December 8, 2022

**Re: Starbucks at 1440 Coors Blvd NW
Erosion and Sediment Control Plan
Engineer's Stamp Date 12/2/2022 (G11E069)**

STORMWATER POLLUTION PREVENTION PLAN INFORMATION

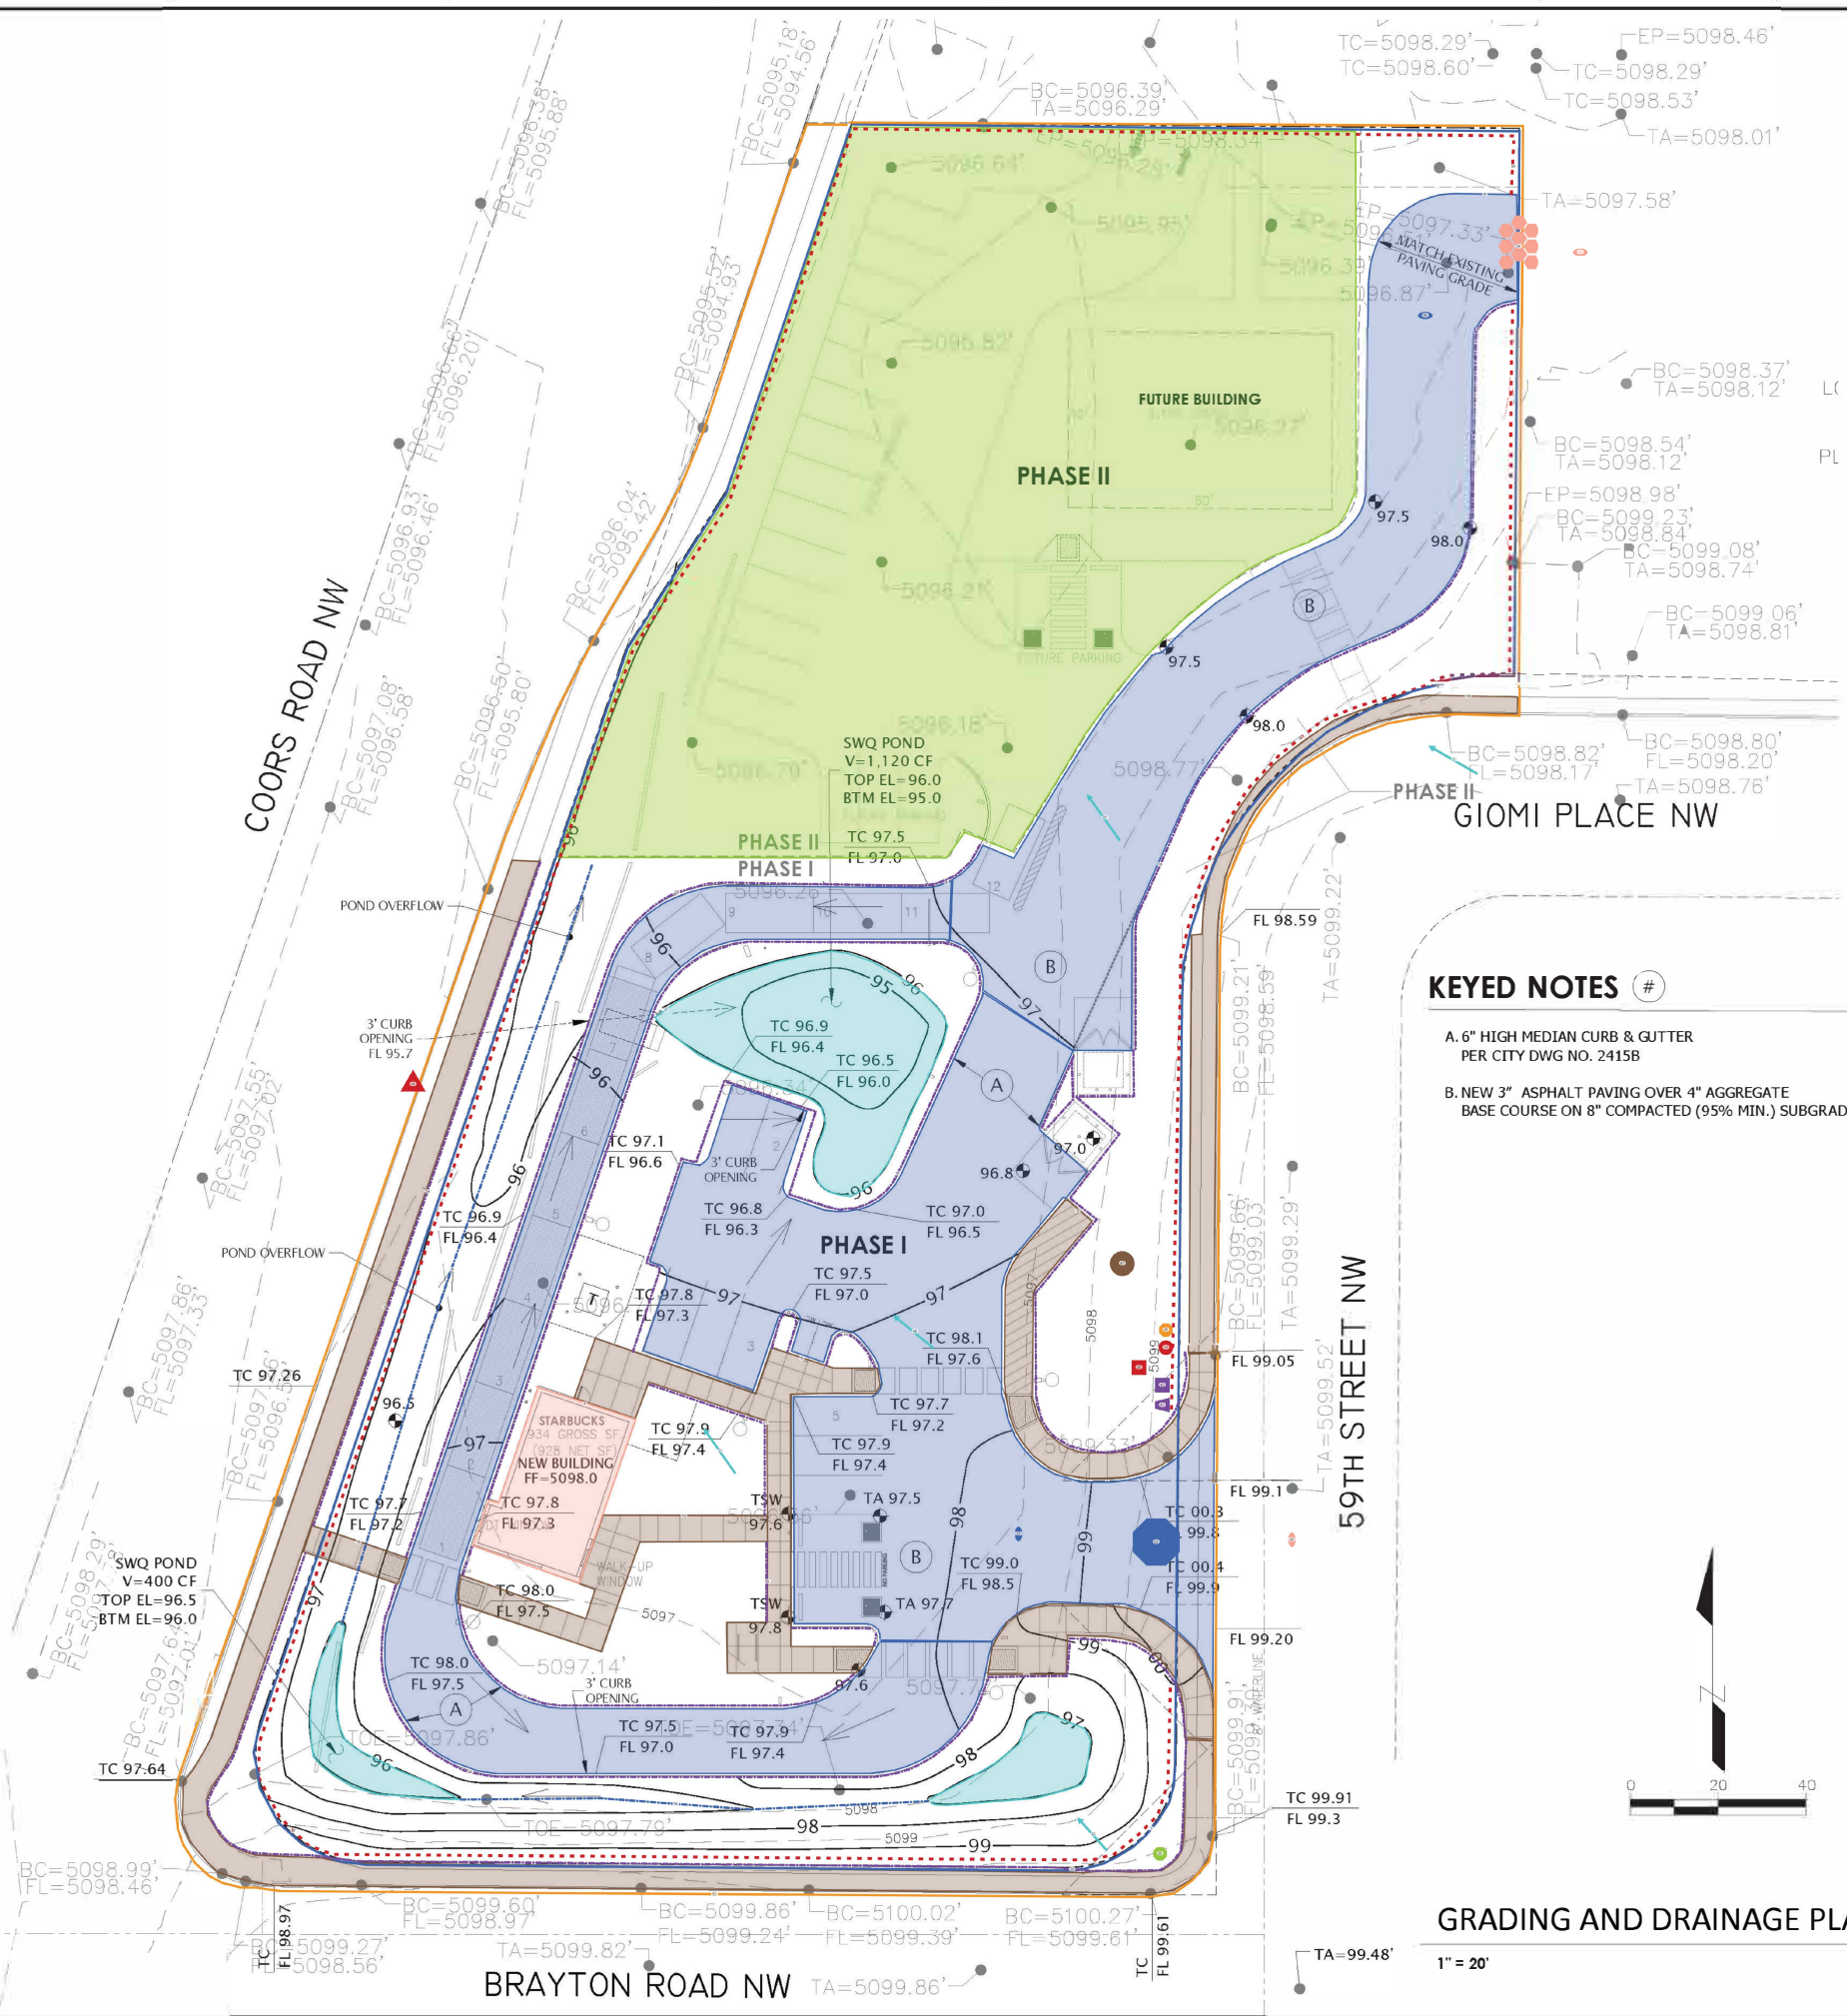
Based upon the information provided in your submittal received on 12/5/2022, the above referenced ESC Plan is conditionally approved to be included in the SWPPP, Work Order, and Building Permit Plans provided that the notes on sheet 2 of 6 are corrected to the actual numbers.

1. Sheet 2 of the ESC plan still incorrectly shows
 - a. the area of disturbance as 0.97 instead of the actual 1.75 acres
 - b. the start date as 10/27/2022 instead of the actual 10/4/2020
 - c. the permit number as NMR10056F and NMR1005G instead of the actual NMR10057V and NMR 10057T
